Fire Marshal Division

Re: Campbell Pointe Town Homes

Application Number BCOM1808-0012

Plan Review Notes

SHEET NO.
LS-1 OF 1

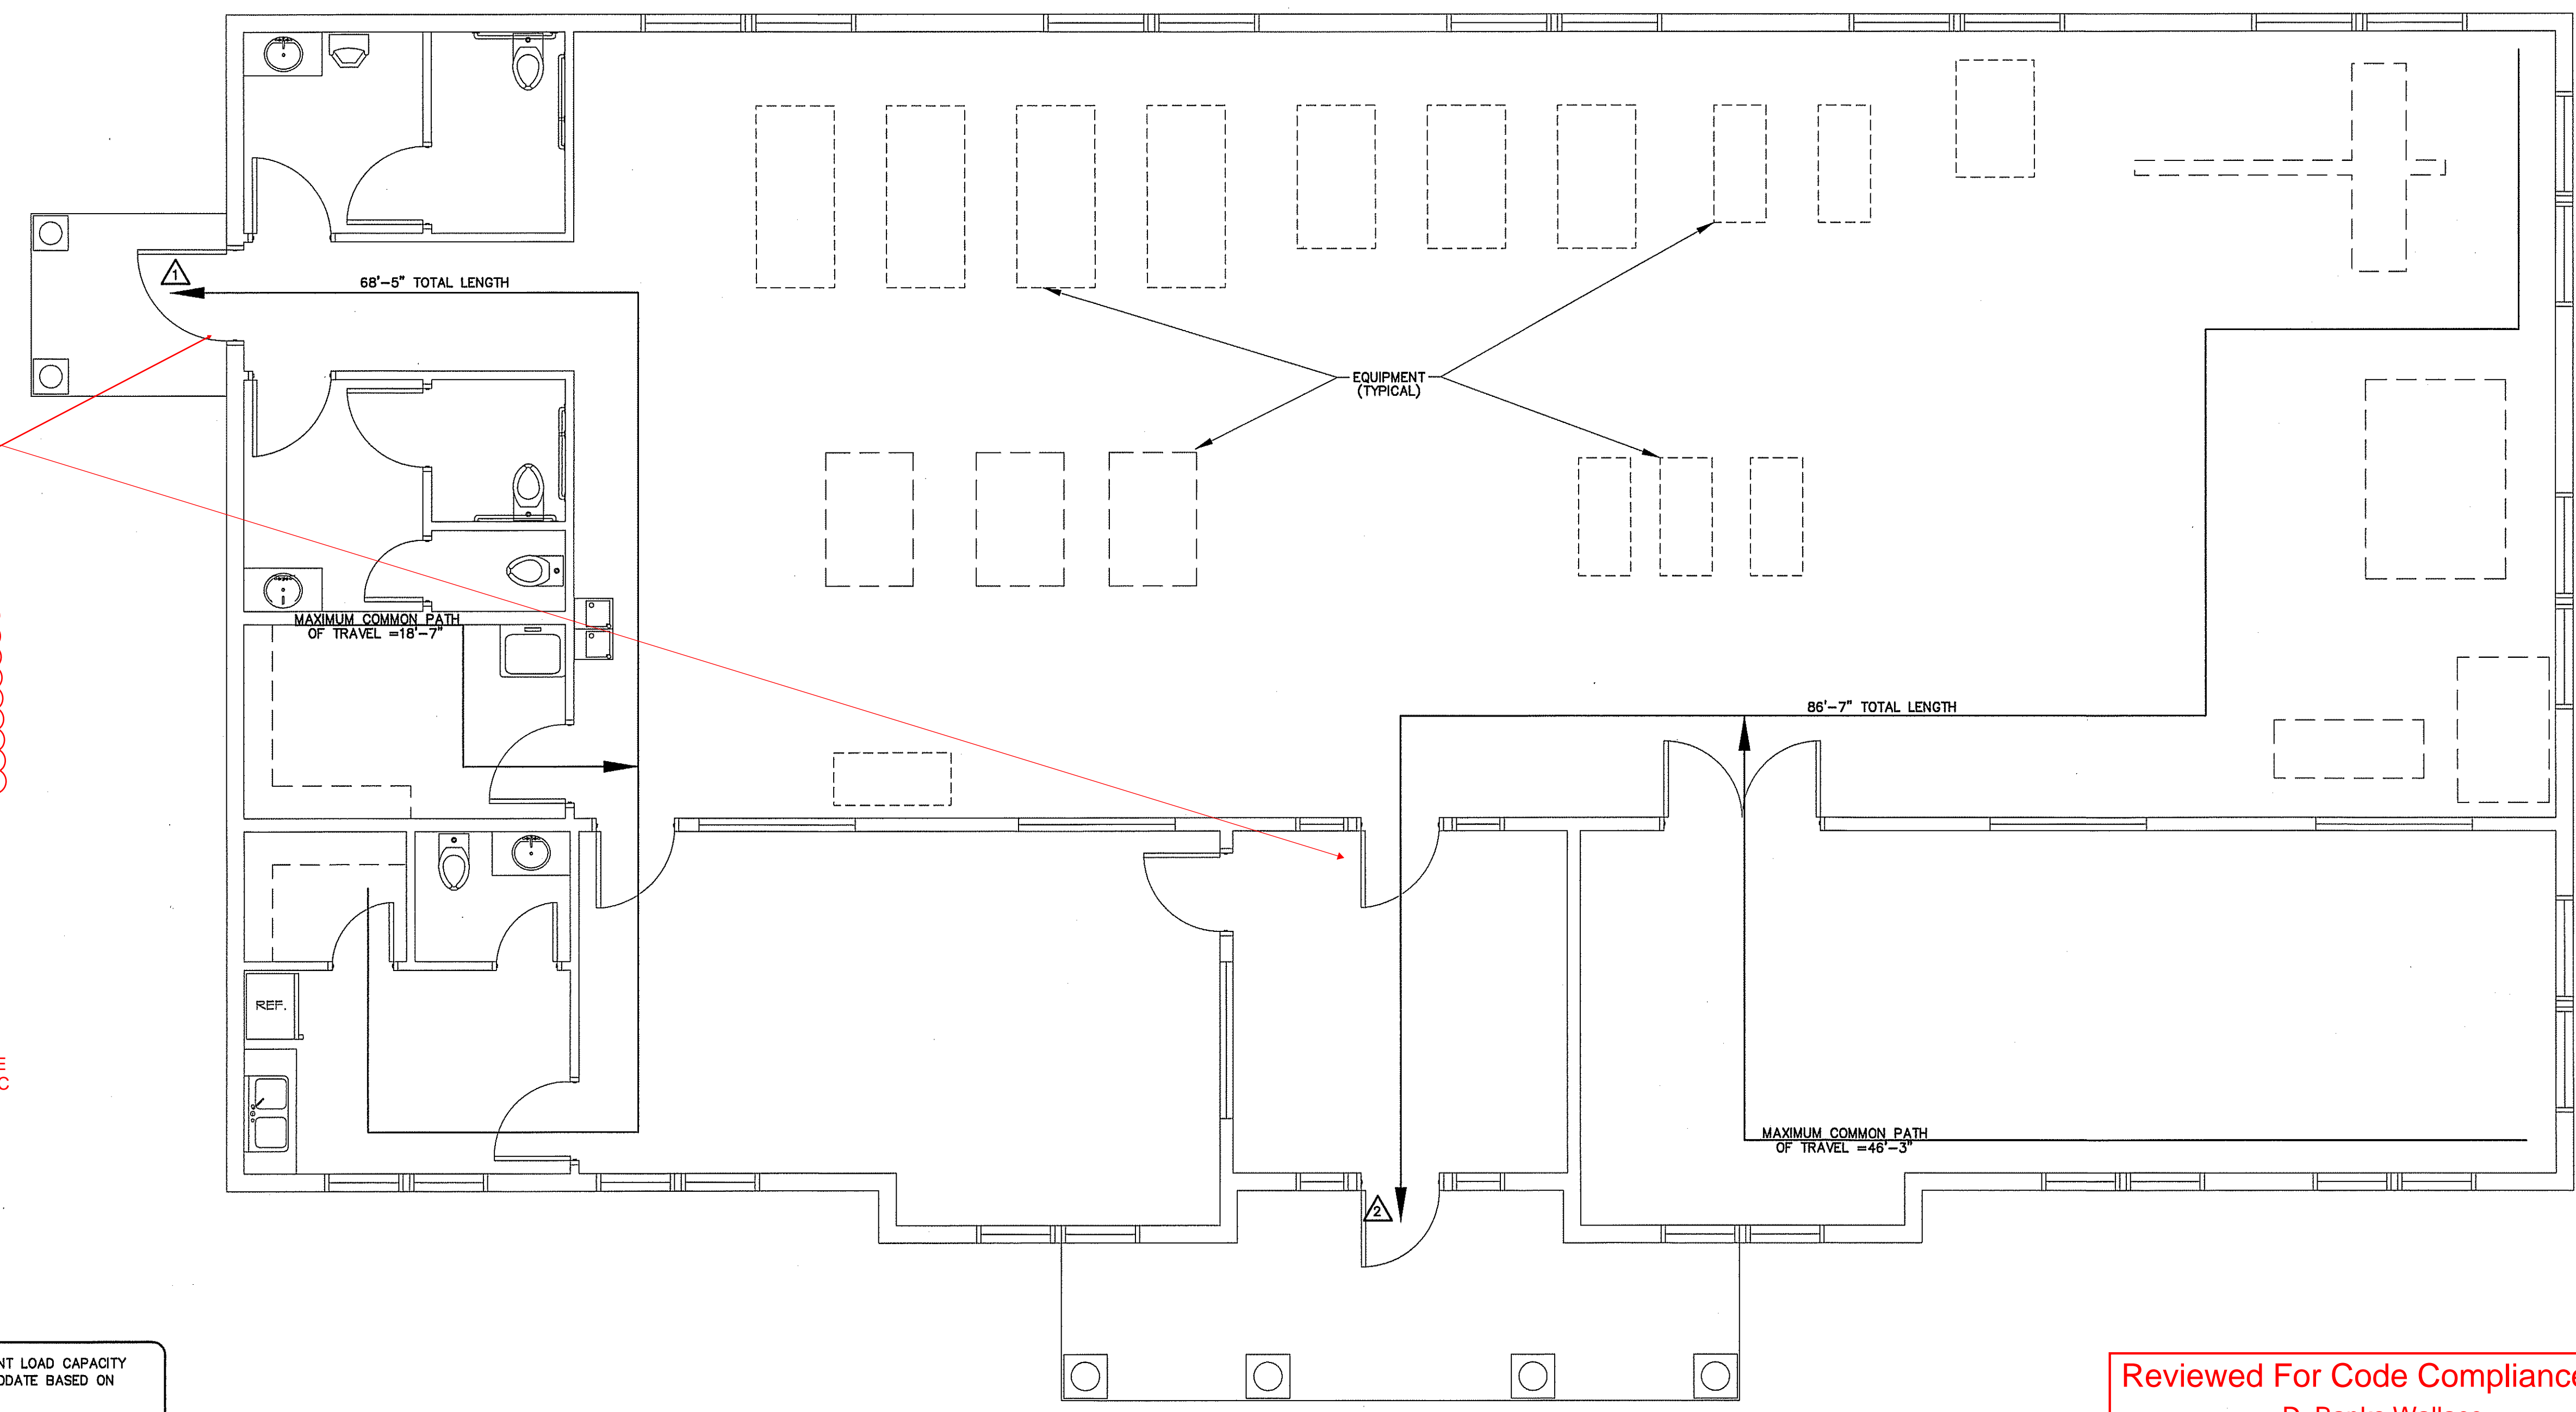
- **1008.1.2 Door Swing**
 - All Exit doors in an Assembly occupancy of over 50 must swing in the outward direction.

- **1008.1.10.1 Panic Hardware**
 - All doors servicing areas with an occupancy load of 50 or more, must be equipped with panic hardware.

- Installation of additional exit lights may be required if lights indicated on plans are not clearly seen from all areas that exit is serving, this may be a result of equipment placement.
- Please note location on plans
